**WEST SUSSEX COUNTY COUNCIL
STRATEGIC PLANNING CONSULTATION**

SUBJECT: BE/129/11 - Proposed gate development

Poplars Park, Frensham Avenue, Shripney Road, Bognor Regis, West Sussex, PO22 9SZ

PROPOSED GATES SITE PLAN
SCALE 1:200

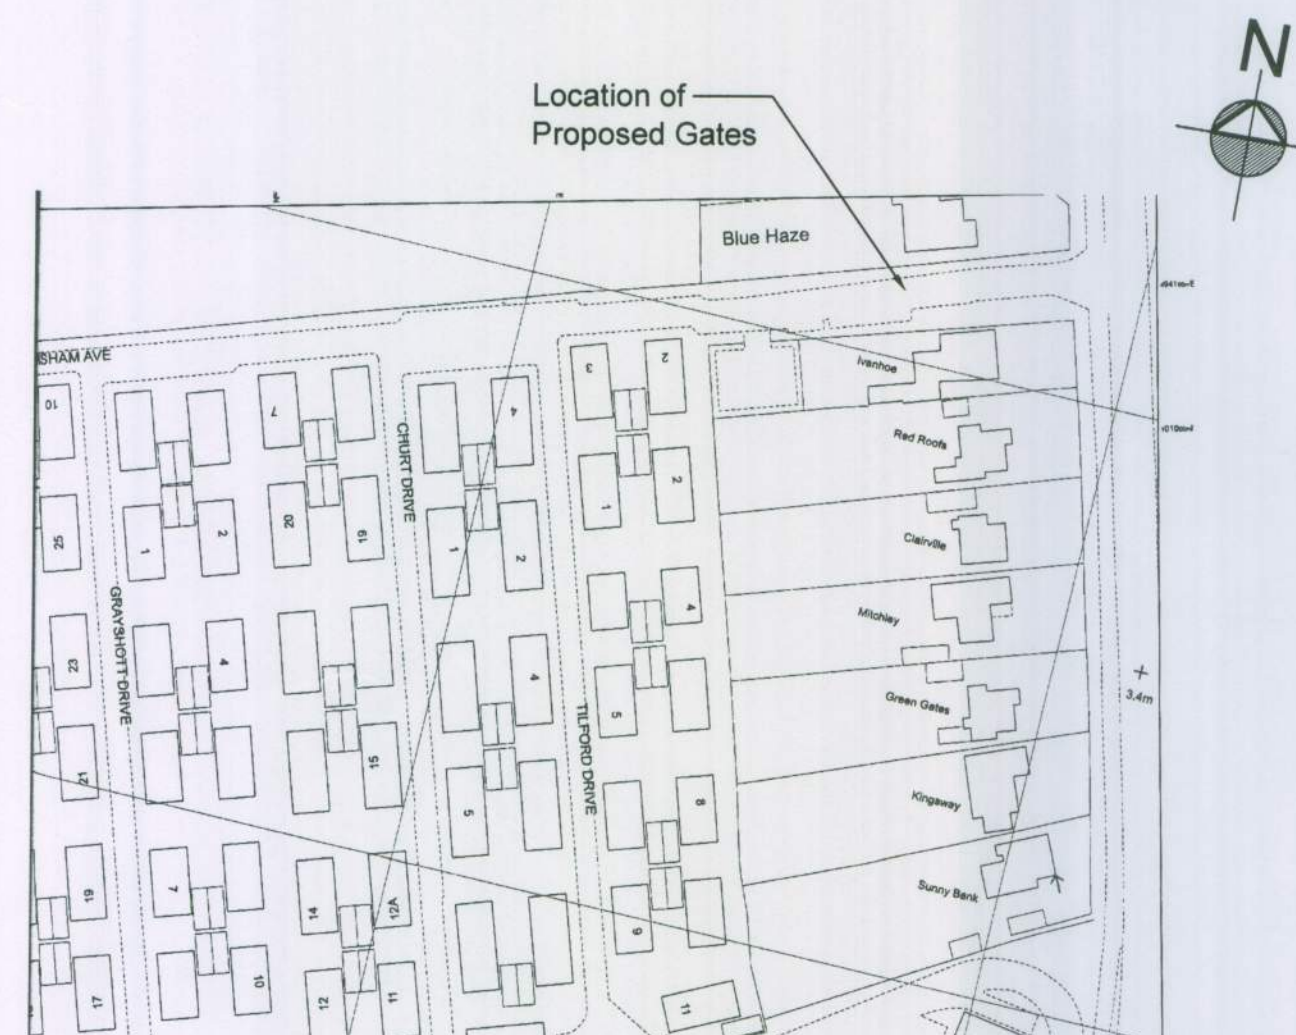
The gates will be open inwards of the site and be set back approximately 30 metres from the public highway. We would consider this set back distance appropriate to allow 5 cars to be removed from the public highway while the gates are opened.

From inspection of the plans there appears to be no apparent visibility issue at the point of access from Frensham Lane onto Shripney Road, which is the closest adopted highway. I have also checked the most recently available verified accident records, which reveals there have been two personal injury accidents in the vicinity of the existing point of access. However these were not due to the road layout and with this proposal not resulting in an intensification of use of the access, I would not consider this to be of detriment to highway safety.

If the LPA are minded to approve this application a condition securing the gate should be applied.
